Please treat as a substitute plan

Please find attached a revised foul drainage drawing as requested.

I haven't got to the position where I have had time to form a likely recommendation on the application, but given the 'No Objection' from the Parish Council the decision would be delegated to officer level.

Title			Proposed New Foul Drainage		
Scale	1:500	At original	A4	© Robert Clark Associates Ltd	
Drawing Number	1772/F/SK2		Revision		-

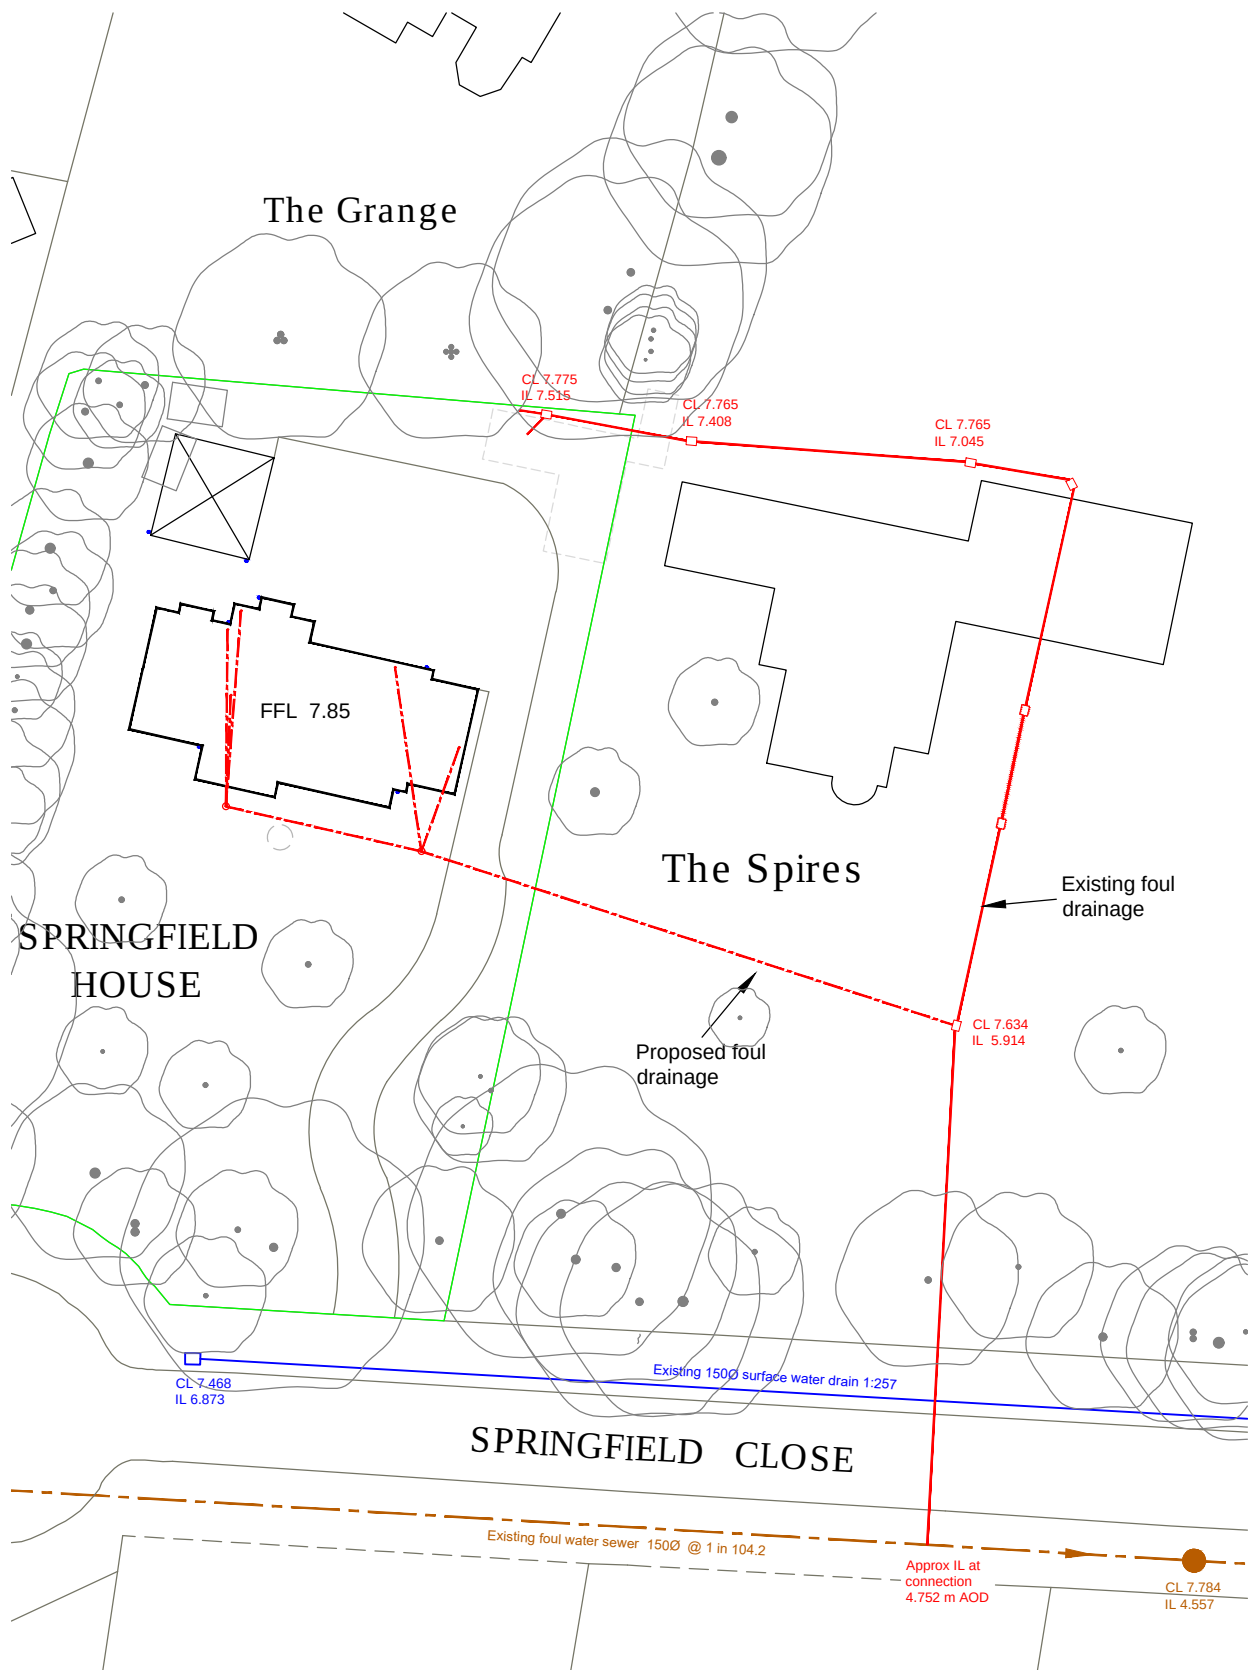
No information is given for how the pool will overflow and backwash. It is assumed that this will go to the foul sewer but this is not shown on the Foul Drainage Drawing. Southern Water will need to be consulted if this is the case. The foul drawing also shows the formally approved 2 bay garage which this application removes. The proposed 3 bay garage is not shown.
